FAO: Planning Department,  
Welwyn Hatfield Borough Council

Ref: 6/2018/0136/LB  
Date: 22/10/2019

## HISTORIC BUILDINGS AND CONSERVATION ADVICE

**RE: *Oshwal Centre, Coopers Lane, Northaw, Potters Bar, EN6 4DG***

DRAWING TITLE
WINDOWS 24-25-26-27

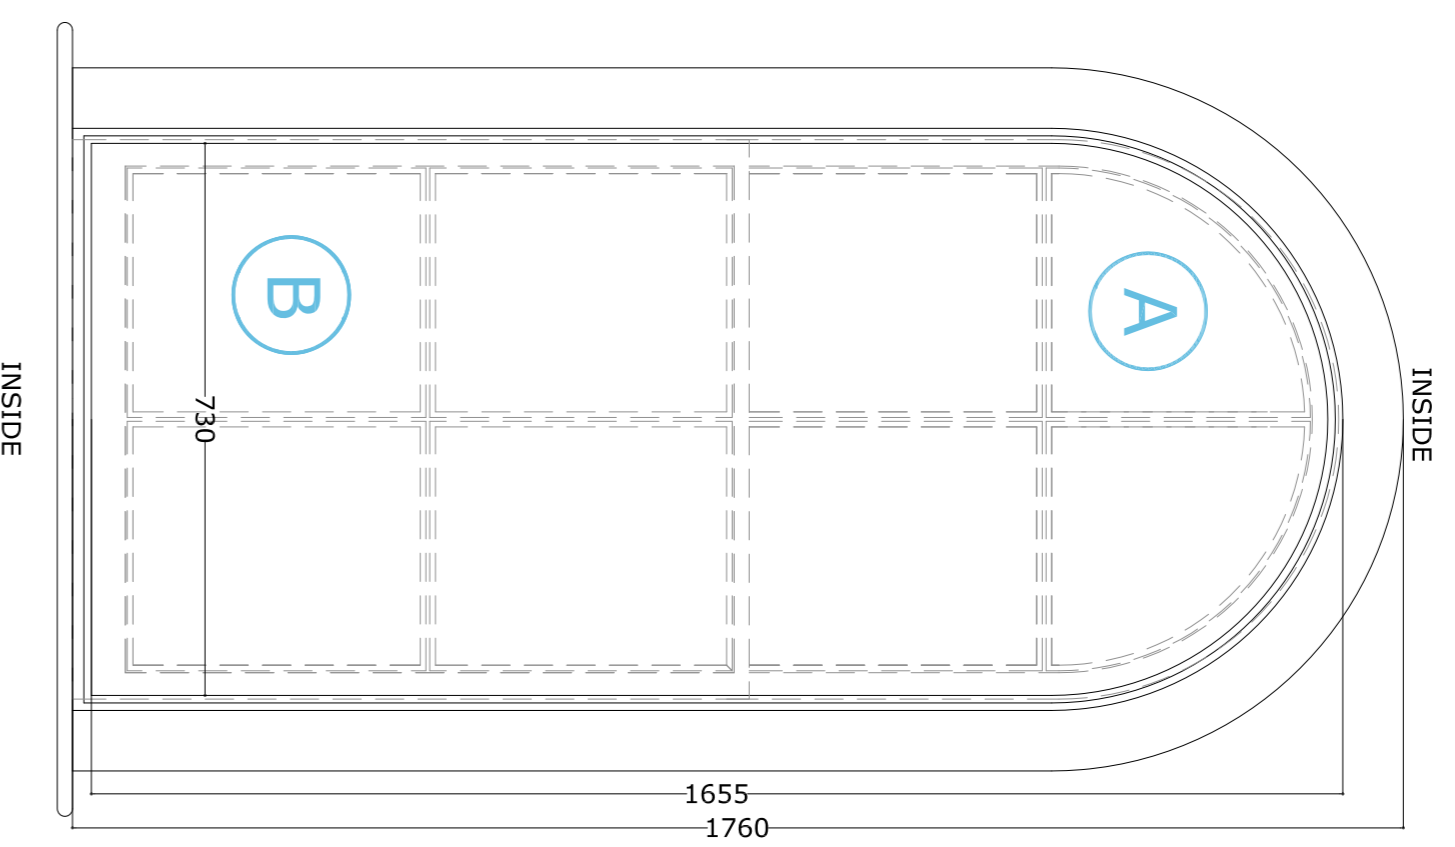
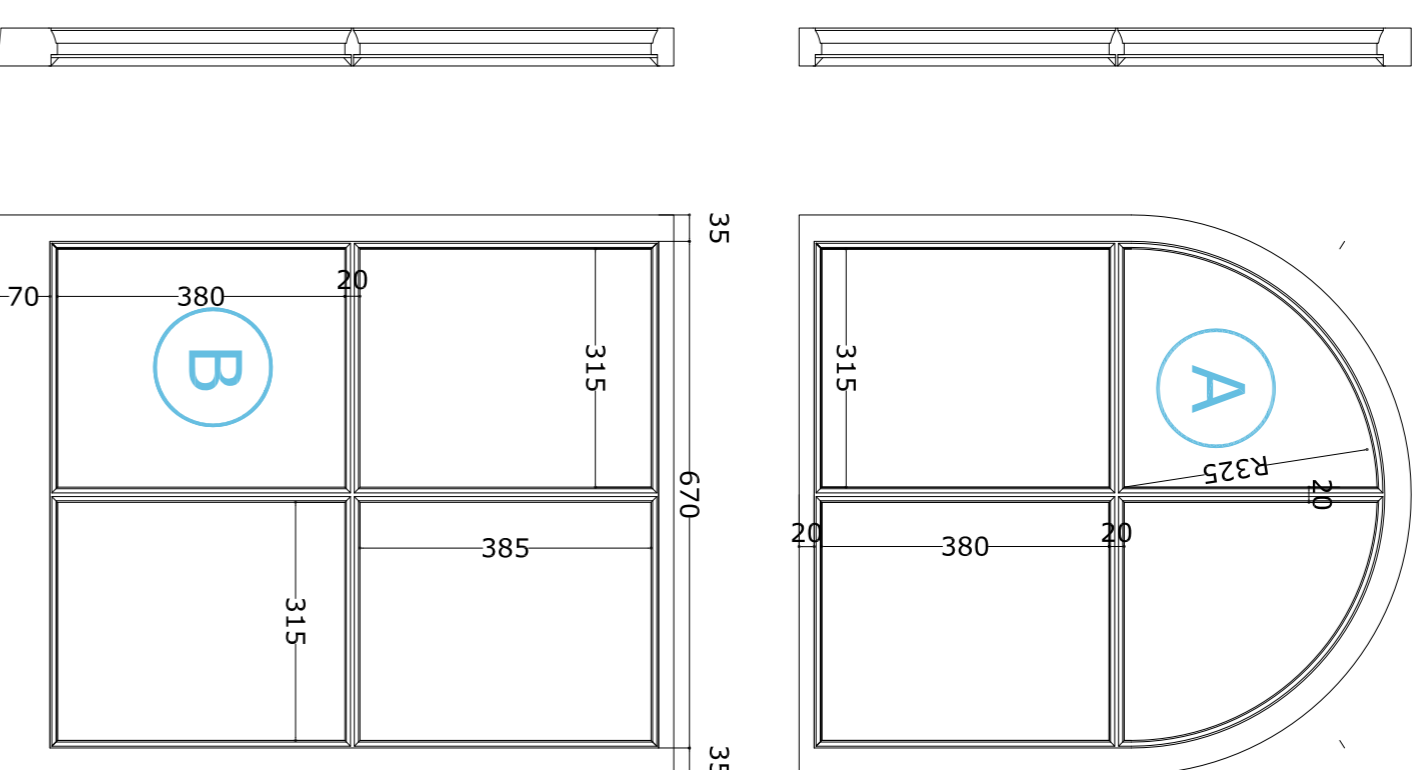
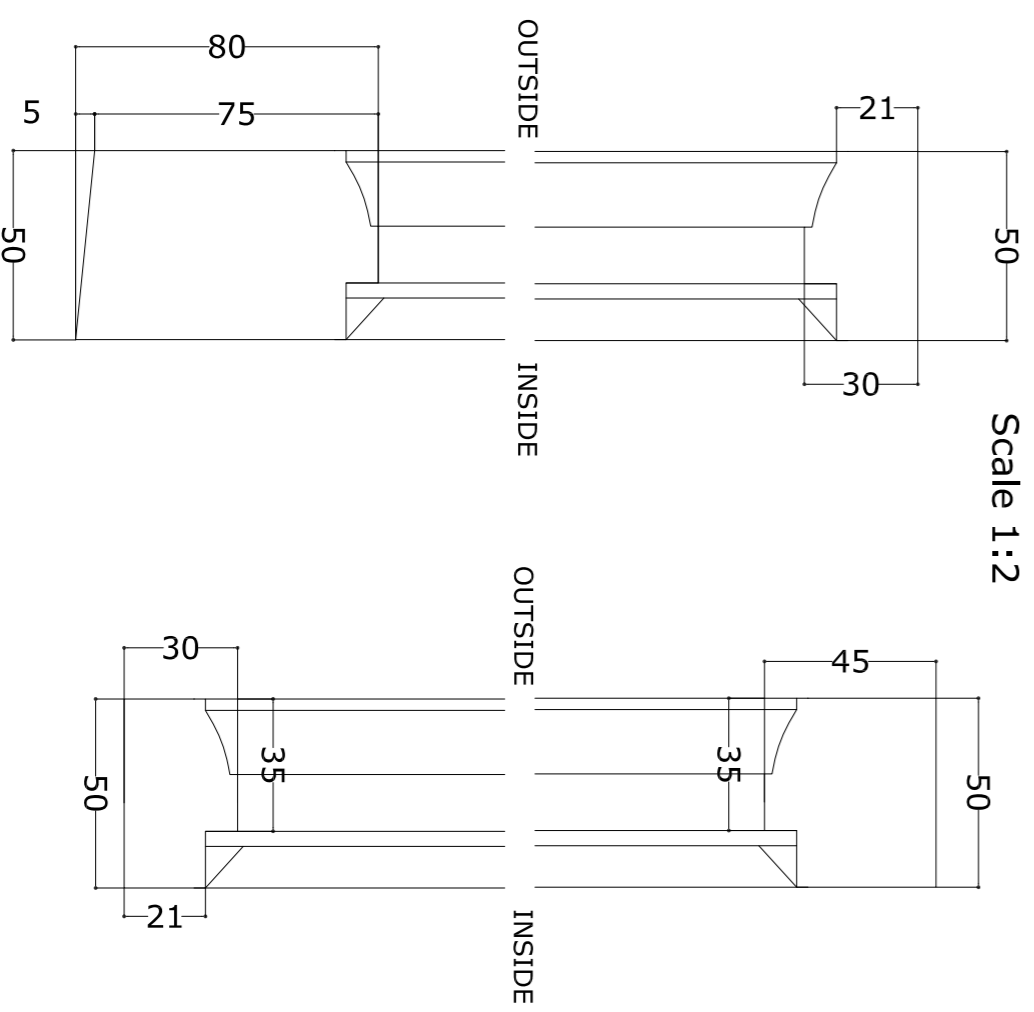
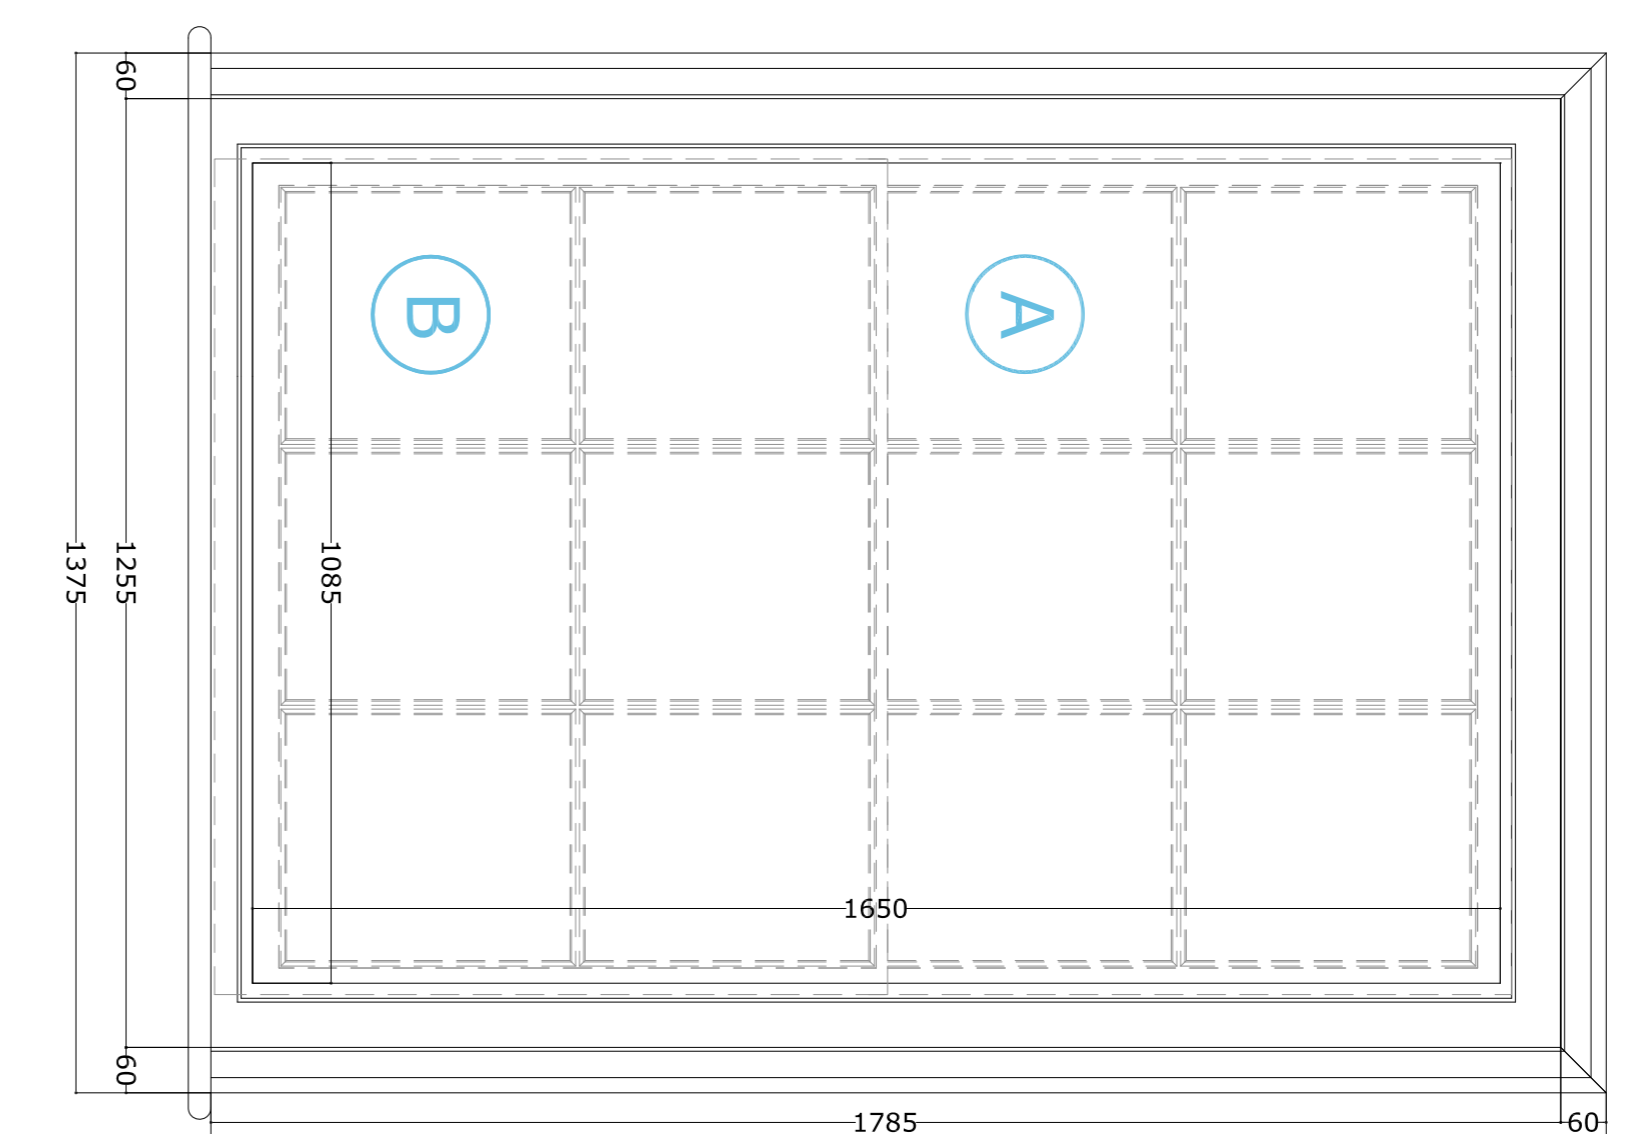
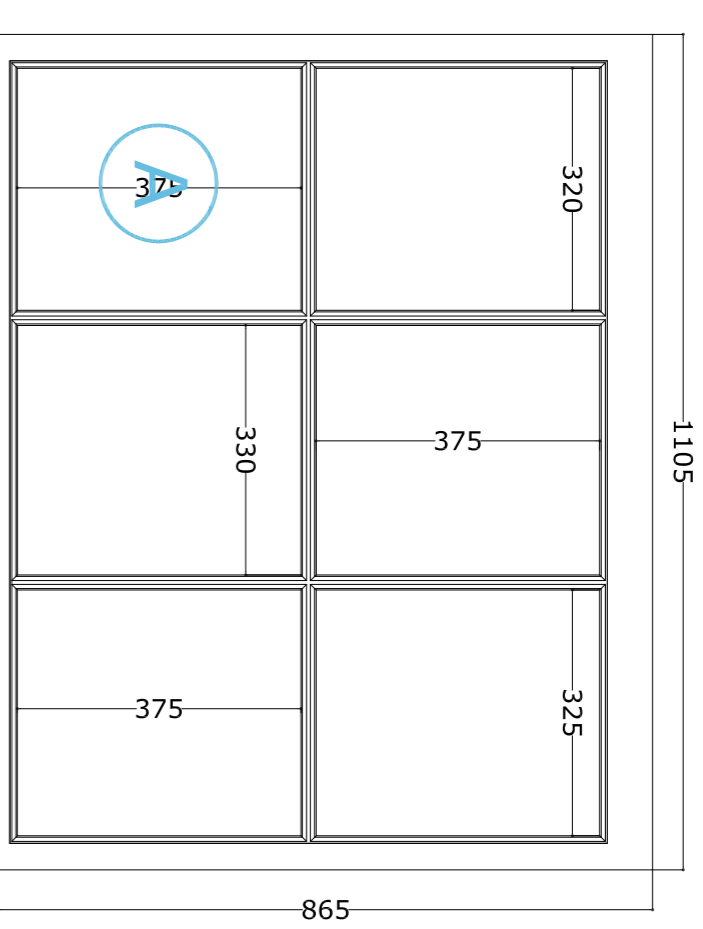
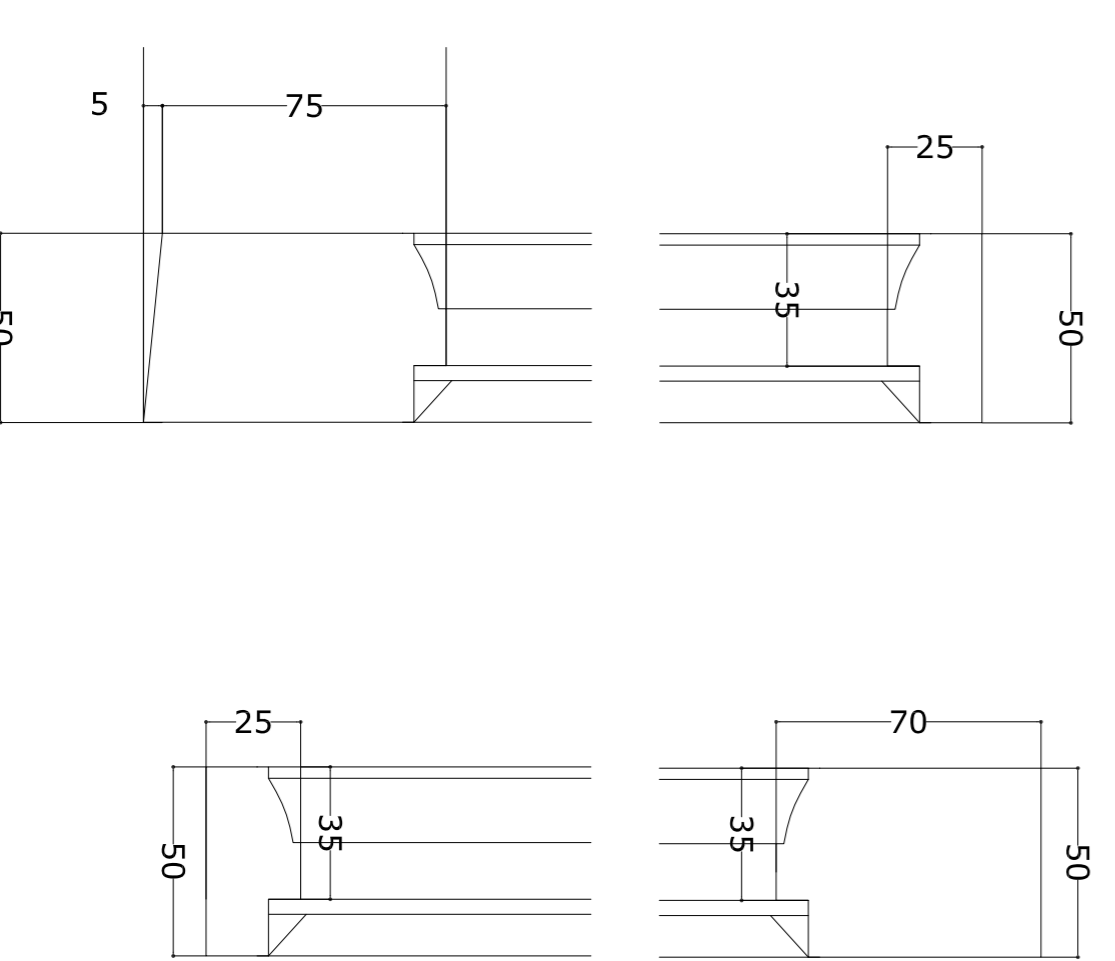
The repair of window nos. 1, 2, 3, 12, 13, 14, 15, 16, 17, 18, 20, 21, 22, 23, 24, 25, 26, 38, 39, 40, 41, 42, 43, 44, 45, 46, 47, 48 (refer to paragraph no. 2.11 of the *Heritage Statement Annex 1* and drawing no. 6842-78-P0) is supported. These windows appear to be original to the 1839 section of the house and therefore relate to the primary phase of the building. However, further detail is required on the repair needed to these windows as the *Heritage Statement* is quite general. Detail is required as to the extent of the repair work, the technique/methodology materials to be used. The proposed replacement of the single glazing with slim double glazing is not acceptable because of the potential loss of historic glass and the untraditional modern appearance of double glazing.

Window nos. 4, 5, 6, 7, 8, 9, 27, 28, 29, 30, 31, 32, 49, 50, 51, 52, 60, 61, 62 (paragraph no. 2.12 of *Heritage Statement*) appear to relate to a later phase of building work dating to the late 19<sup>th</sup> century. They are still of interest as historic elements of the building and their difference to the windows above is important in denoting the historic evolution of the building. Whilst not part of the primary phase, they are still of historic interest. It is recommended that these windows are also repaired and

only replaced if beyond viable repair. The replacements should be on a like-for-like basis including single glazing. Double glazing will not be acceptable.
